Reference No:	2025/62/91605/W
Site Address:	6, Furnbrook Gardens, Kirkheaton, Huddersfield, HD5 0DY
Description:	Erection of first floor extension
Recommending Officer:	Elenya Jackson

Officer Report

Proposal: Erection of first floor extension

attic floor plan

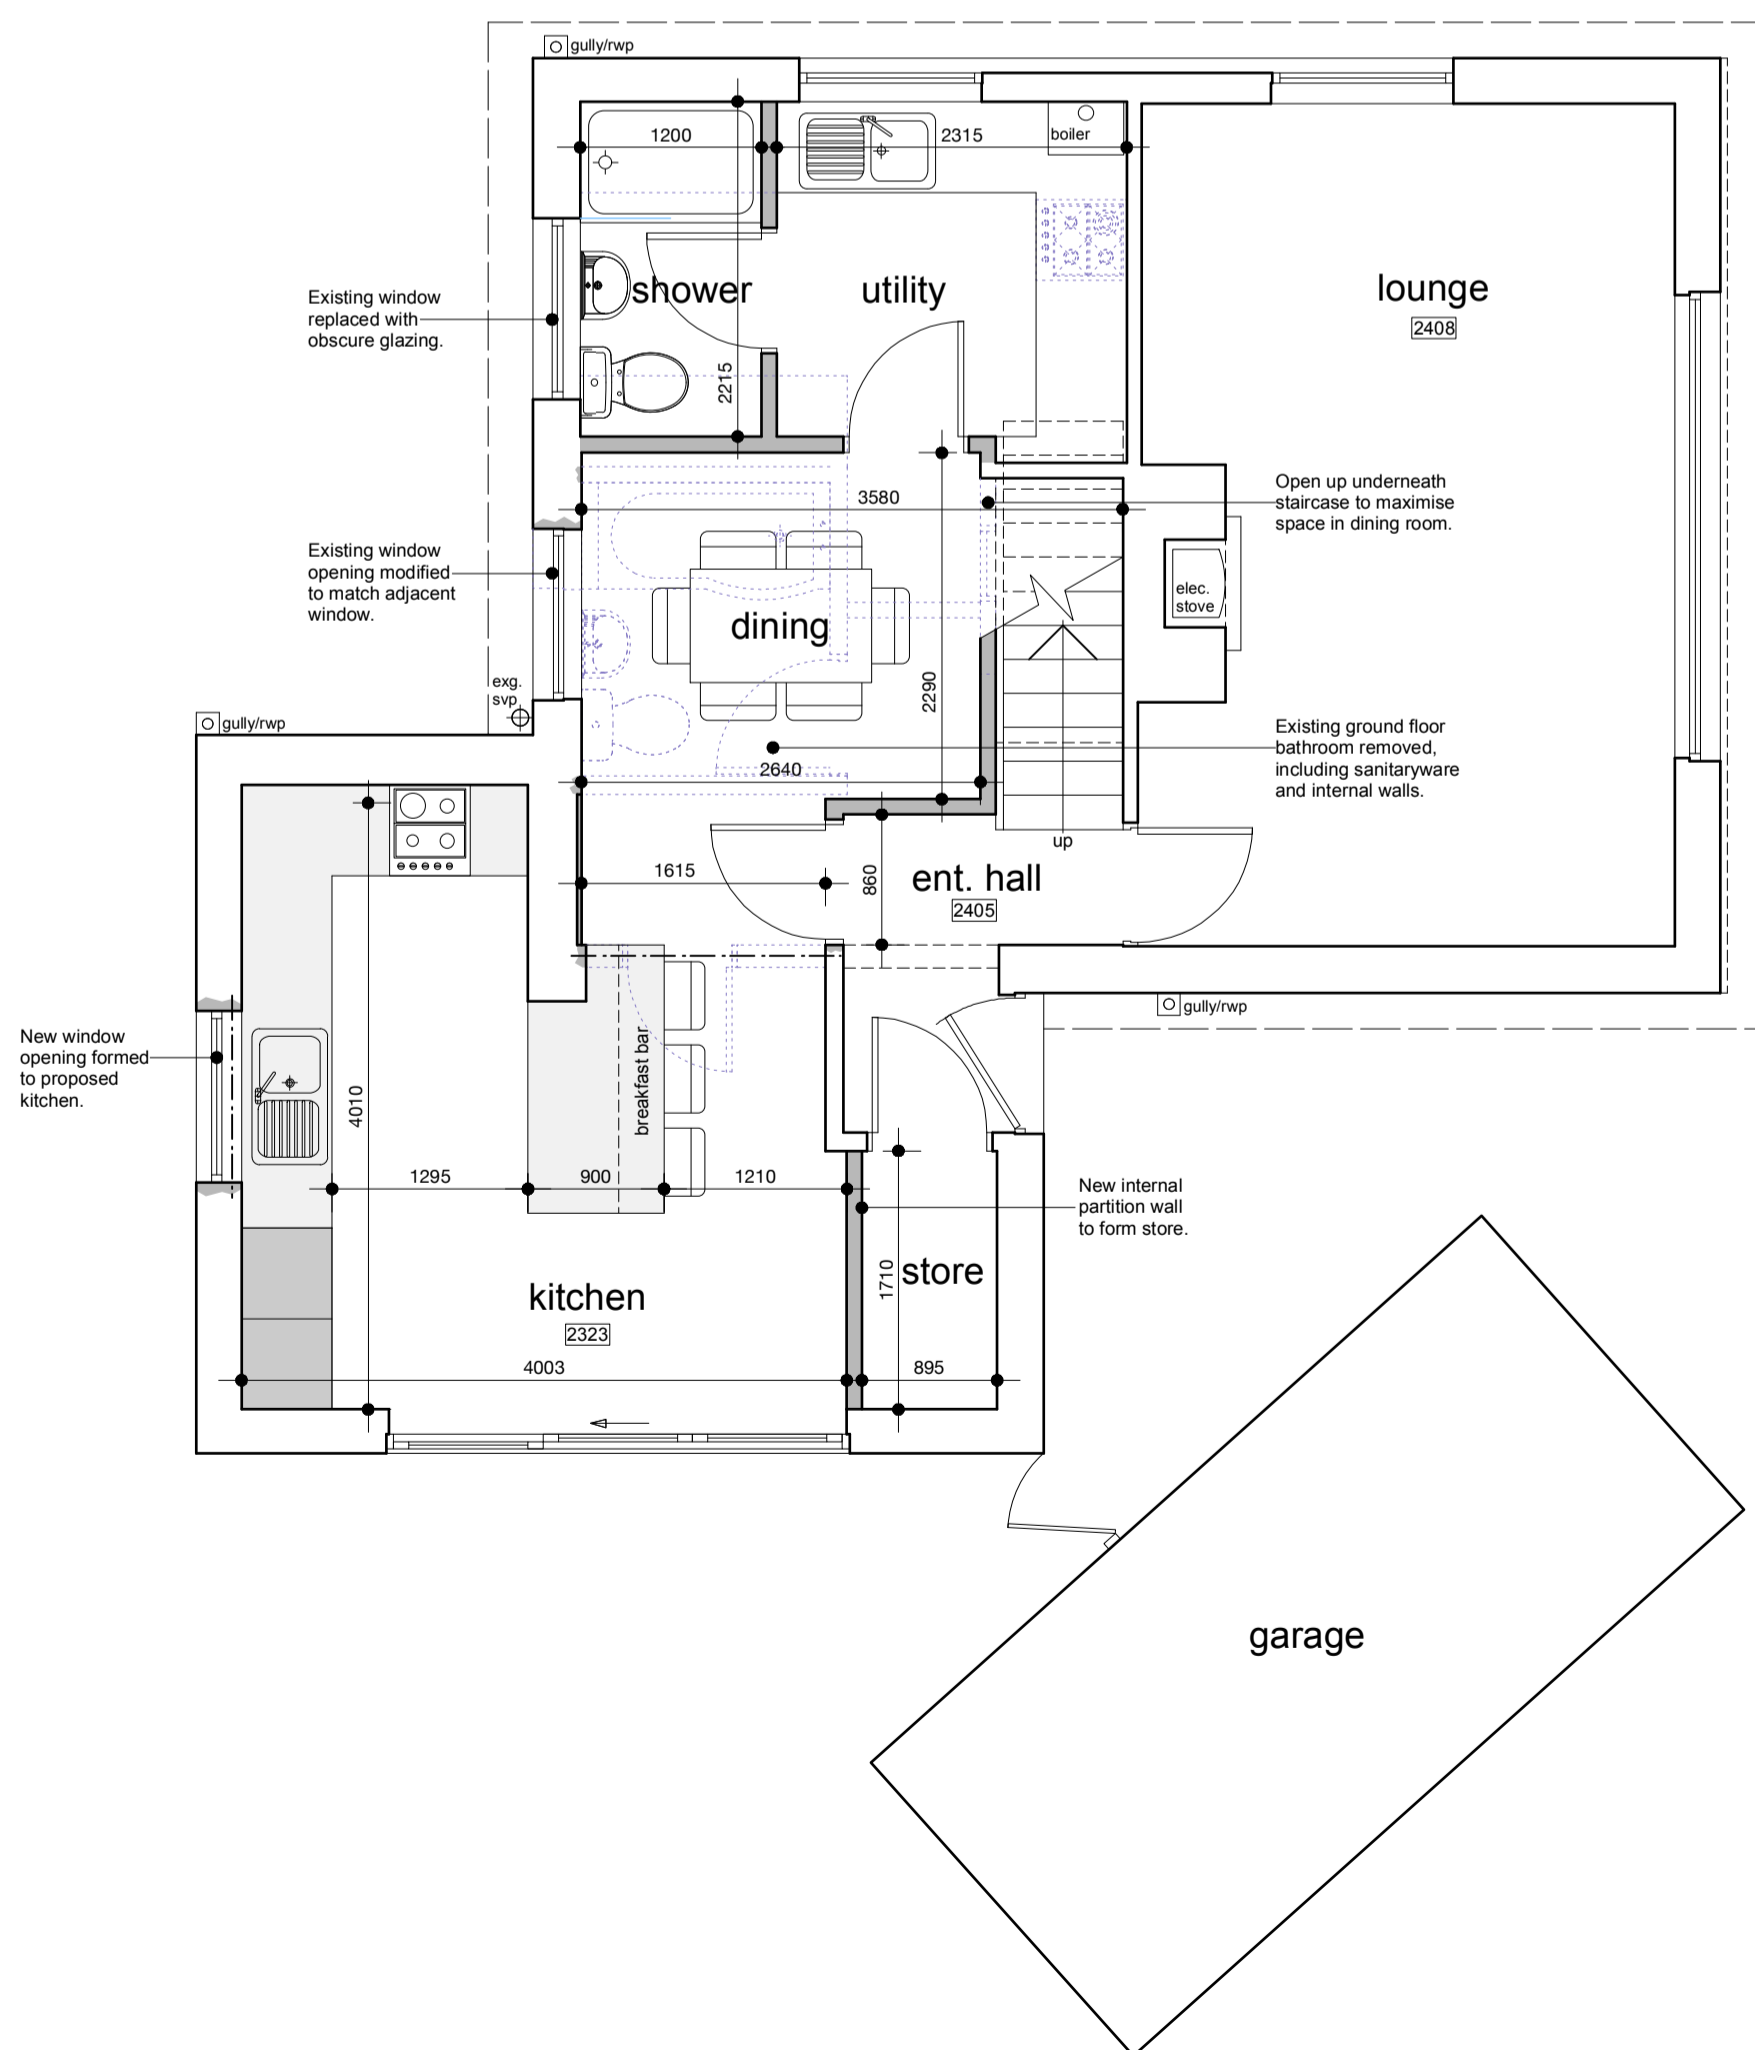
- First floor extension over existing dining room. This would project 3m beyond the side elevation of the house with a maximum height of 5.7m and a width of 5.6m
- Addition of a front and rear dormer which would have a width of 3m
- Alterations to fenestration on host building.

east elevation - front

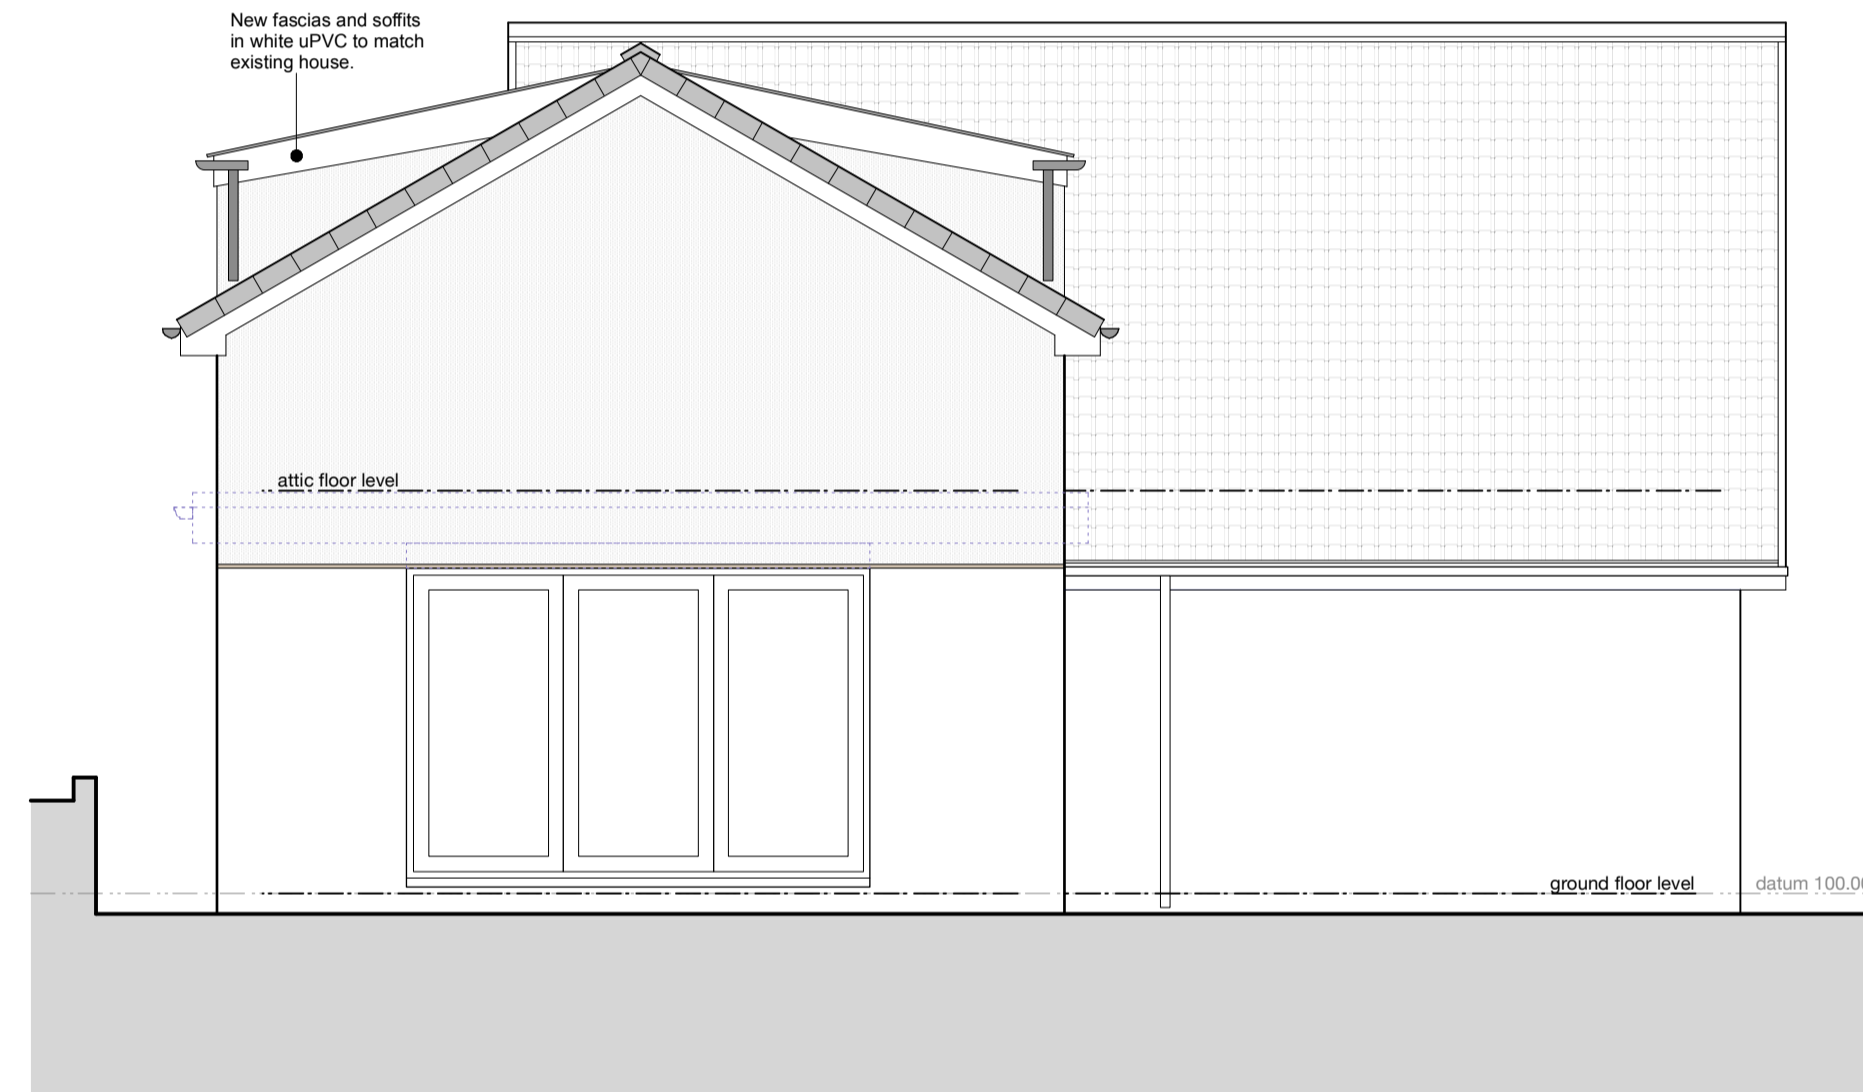
The submitted plans demonstrate that the proposed extension would feature a dormer in the front and rear elevation of the dwelling. Officers consider that there are other examples of dormers within the street scene and therefore they would not appear overly discordant in the public realm.

The proposed alterations to the windows would be considered marginal in the context of the host dwelling as the location of the windows would remain largely unaltered. Given that the fenestration proposed would be of an appropriate design and scale, it is considered to respect the appearance and character of the host property and surrounding area.

block plan 1:200

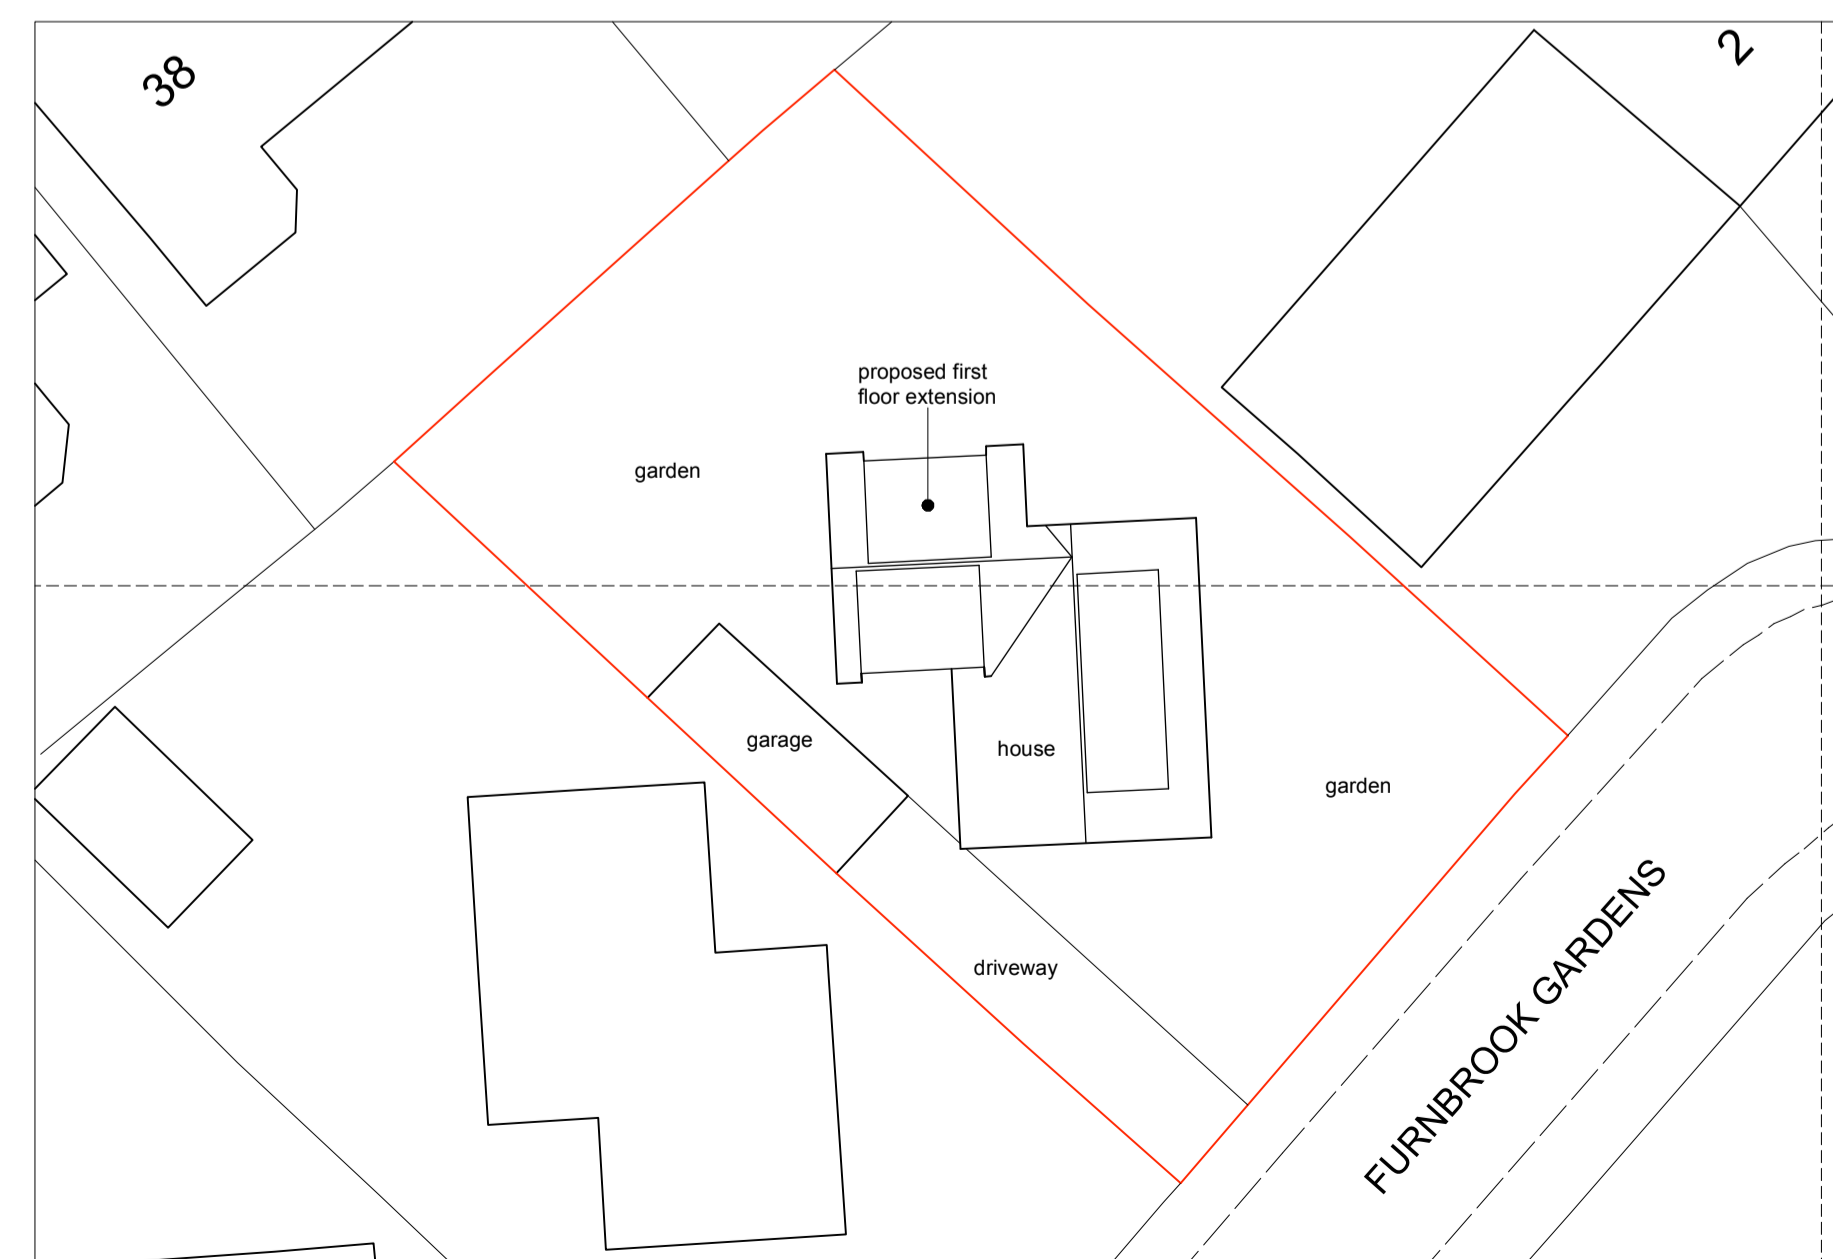
Overlooking: The proposal would add one rear facing window towards no.40. There would be 16.5m between the rear of the application site and no.40 and approximately 9.4m between the proposal and the shared boundary. Officers consider that as the relationship between the properties is offset and there is not a direct relationship, no significant issues would be raised regarding overlooking.
